Application Reference:- FP/106/18/HH

Two storey rear extension & new front dormer roof window

29 Roundle Avenue, Felpham PO22 8LL

DRAWING
PROPOSED PLANS
DRAWING No
259/04
SCALE 1:100
DATE MADE 2018
REVISION
DRAWN
CHECKED
LA

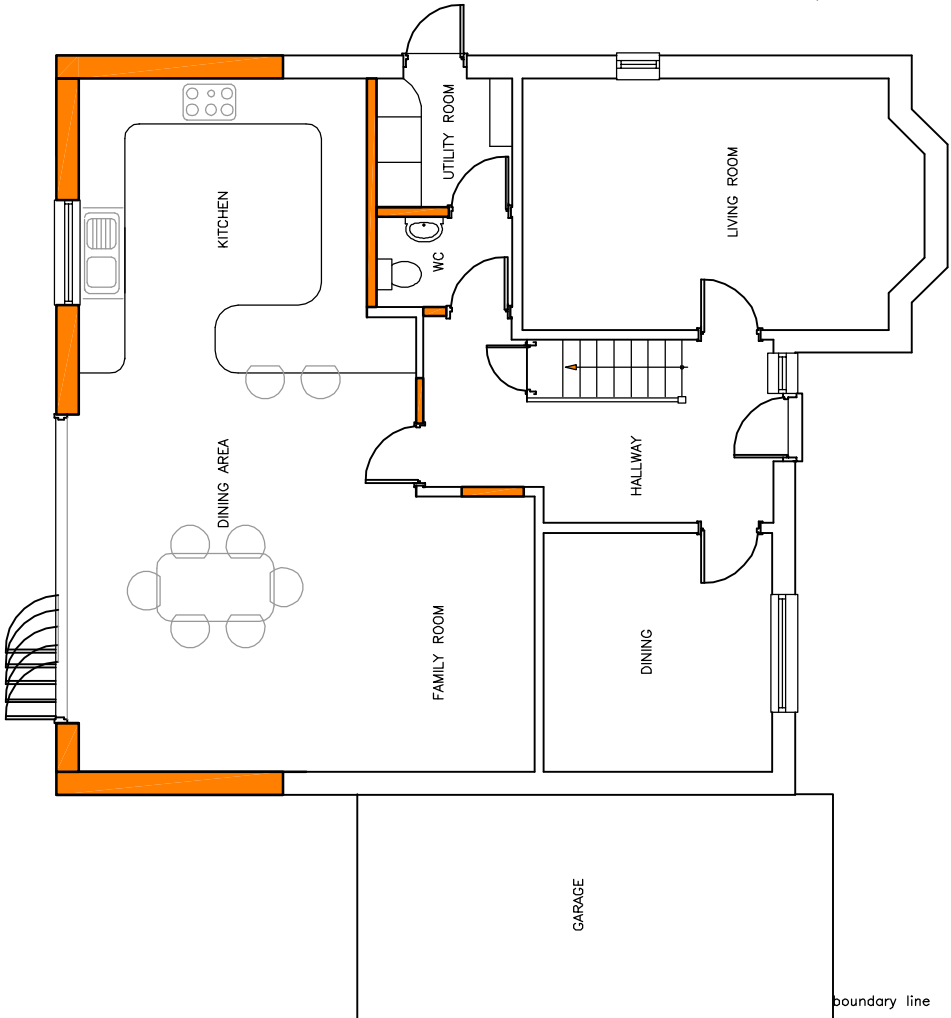
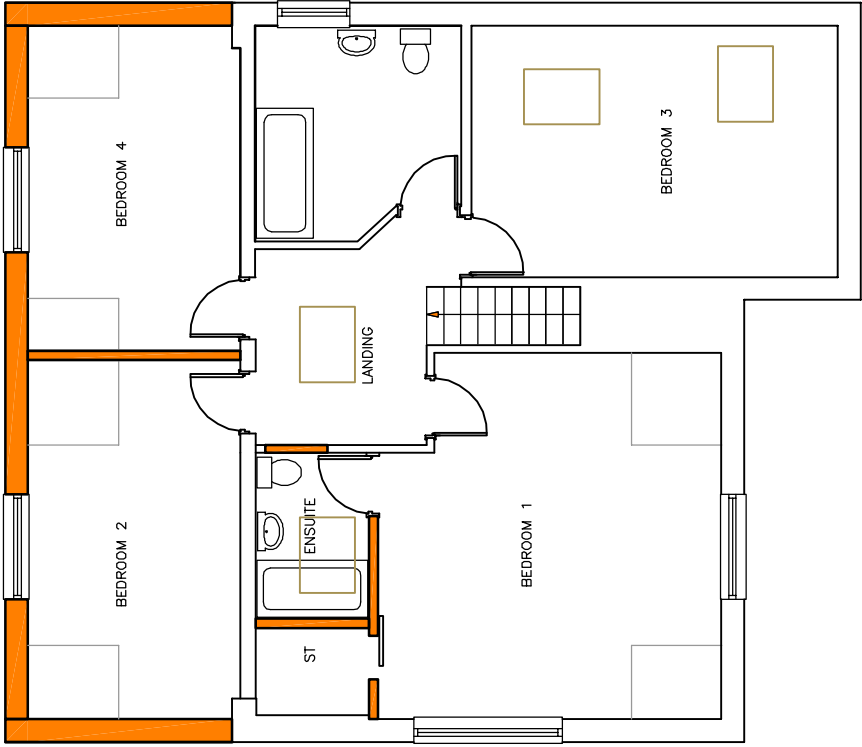
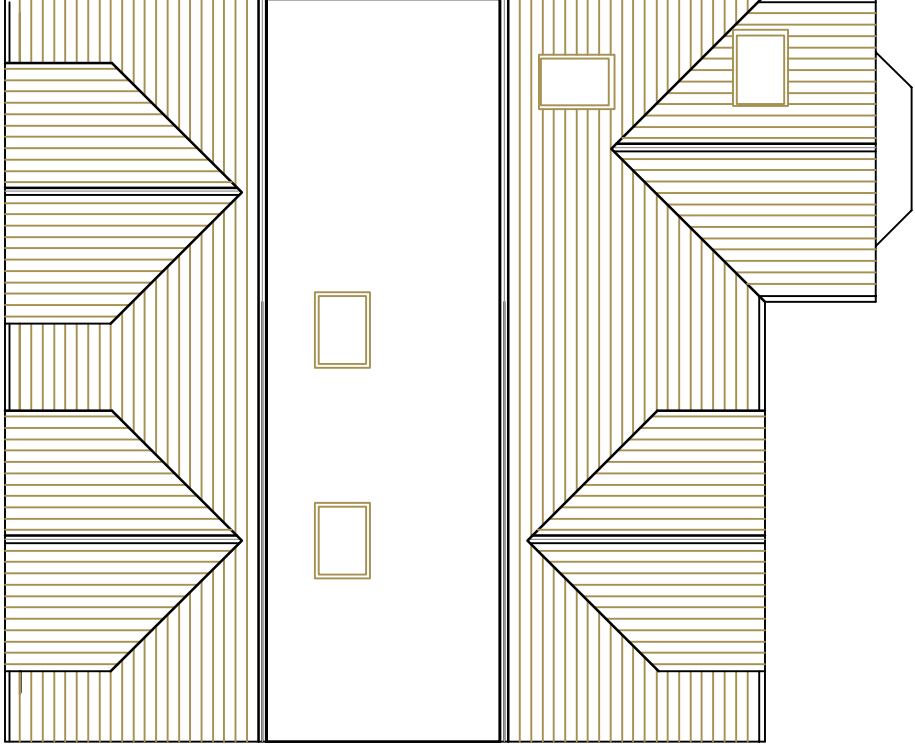
At the outset we would like to highlight that the north point on the Floorplan drawings is inconsistent with the one on the Location and Site Block Plan. Also, the Site Block Plan is considered to be misleading as it has only part of the "new two-storey rear extension" shaded in - the central two storey flat roof area has been excluded from this annotation.

We feel that loss privacy relates to noise and disturbance as well as overlooking and with this in mind we do feel that the position and proximity of the proposed bathroom window is un-neighbourly. Its exact position is not clear as the Proposed north-east elevation drawing is inconsistent with the Proposed First Floor Plan (and the door below it) but, in any event, it is shown with a hinge to the side and there is no confirmation that it would be obscure glazed. The relationship this would have with our property is considered to be unacceptable. With regard to this matter we note that there are two glazed areas on the proposed flat roof (to serve the landing and en-suite) and this could have been an option for the bathroom too.

PROPOSED NORTH-EAST ELEVATION 1:100

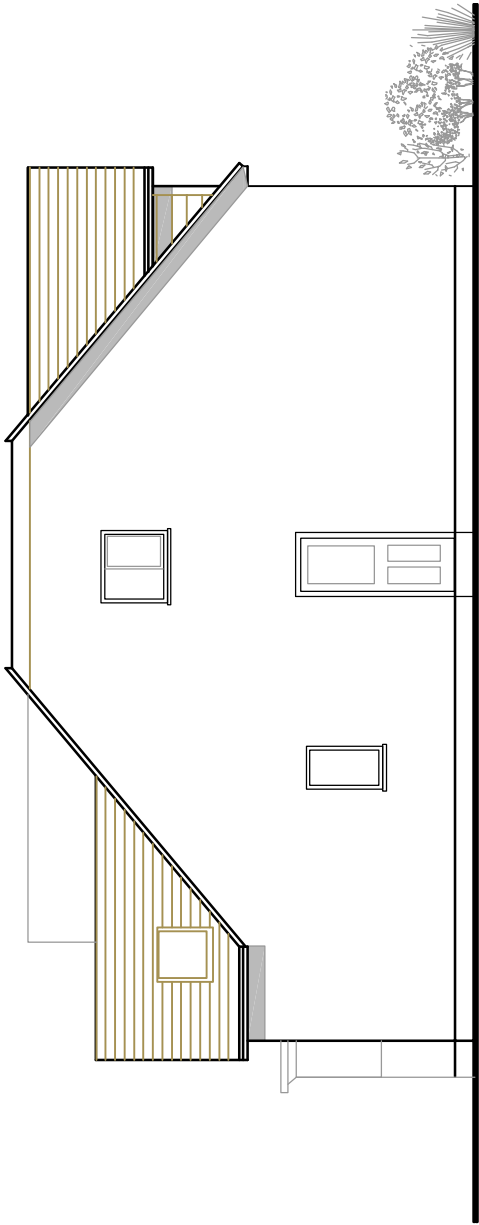
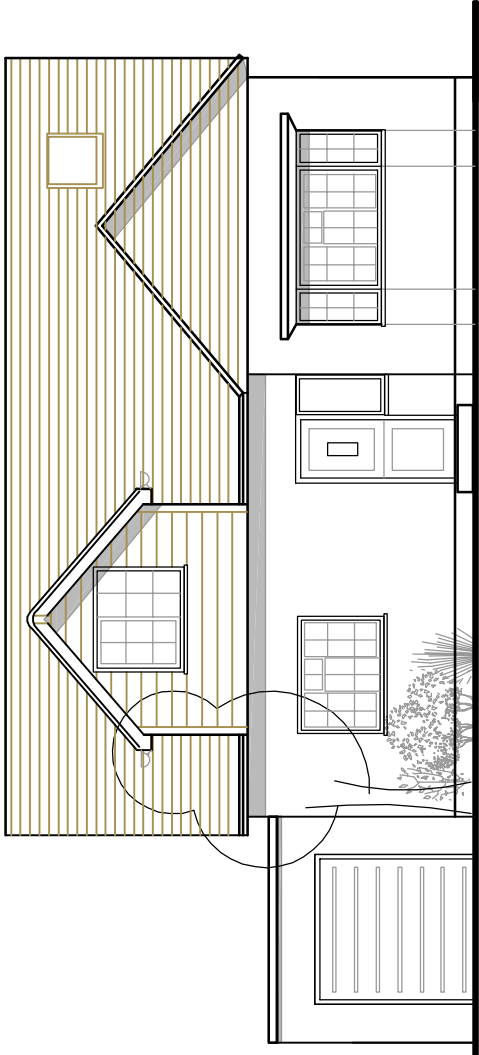
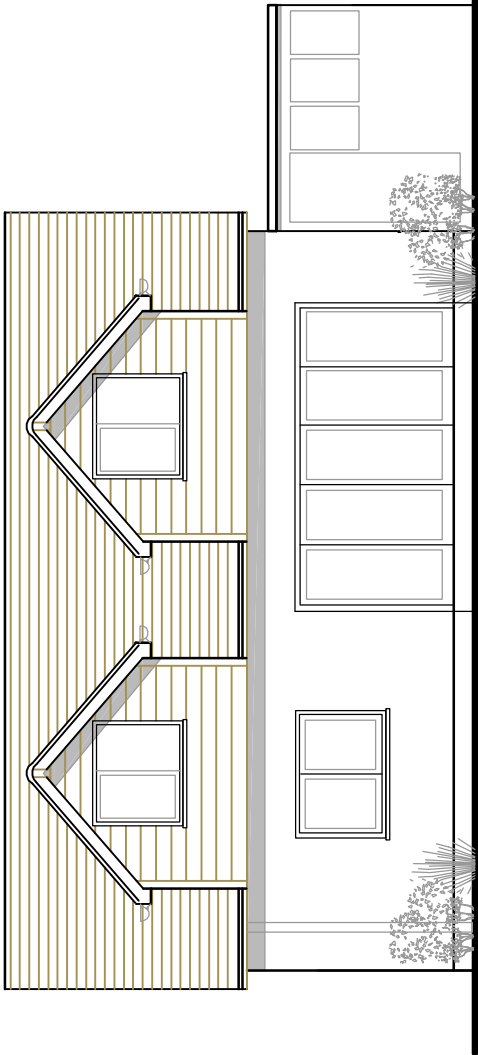
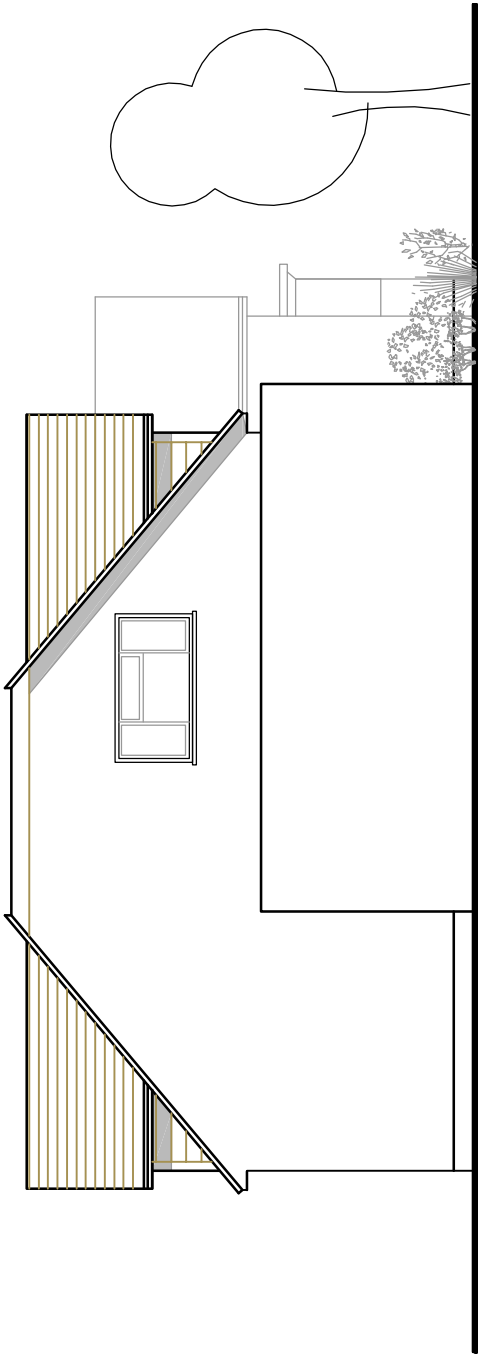
In overlaying a tracing of the existing north-east elevation drawing over the equivalent proposed drawing it is clear to see that the amount of bulk at first floor level would be overbearing from our point of view. This change involves a new gable end with the introduction of a large central flat roof as well as a dormer which would be flush with the new rear elevation and nearly as high as the flat roof.

Without prejudice to our Objections above, should the Application be approved we would like to request that a condition is imposed which would ensure that the proposed bathroom window on the north-east elevation is fitted with obscure glass (high level 4 / 5 on the Pilkington scale) and is fixed shut up to 1.7m above the finished floor level. The window shown on the plans does not include a high level opening. We would also like to request a condition which would require Permission for any other upper floor windows on the north-east elevation. These could serve the bedrooms and, as we understand it, the current 'permitted development' legislation does not specify a level of obscurity.

SITE BLOCK PLAN 1:500

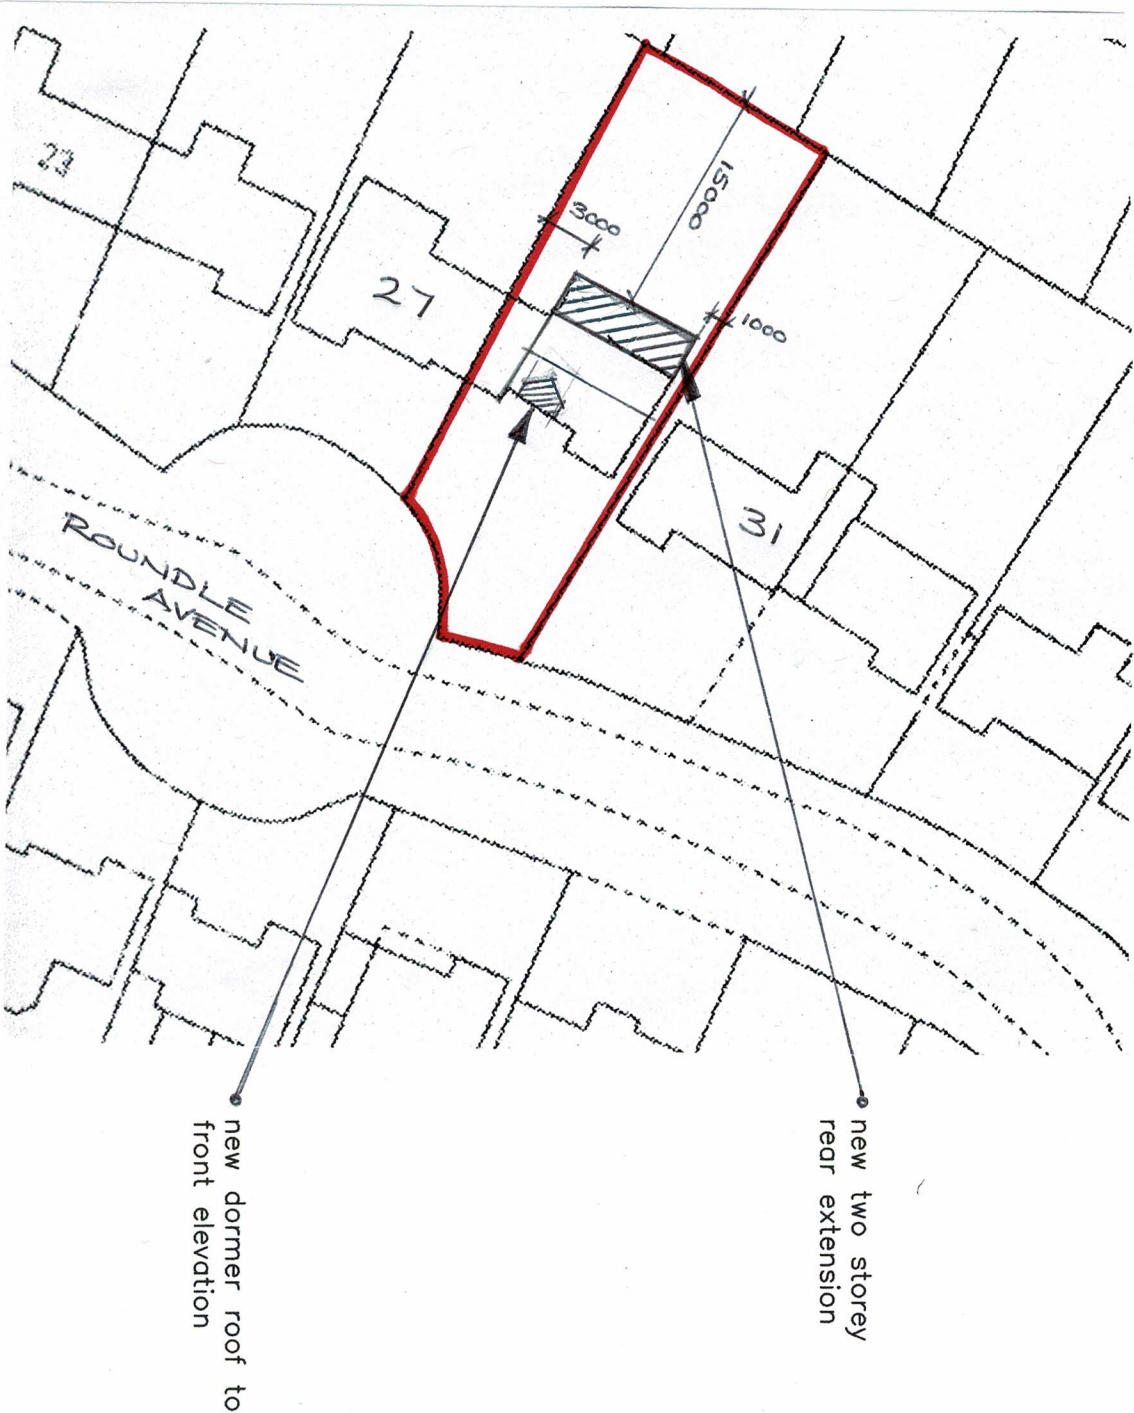
The central flat roof and new pitched roofslope would extend beyond the rear elevation of our bungalow for a considerable distance as confirmed by the Site Block Plan. The flat element would be wider than the flat roof of the garage at no. 29 at the height of the existing ridge. Also of particular note is that the entire new roofslope and dormer would be beyond the existing rear elevation of no. 29.
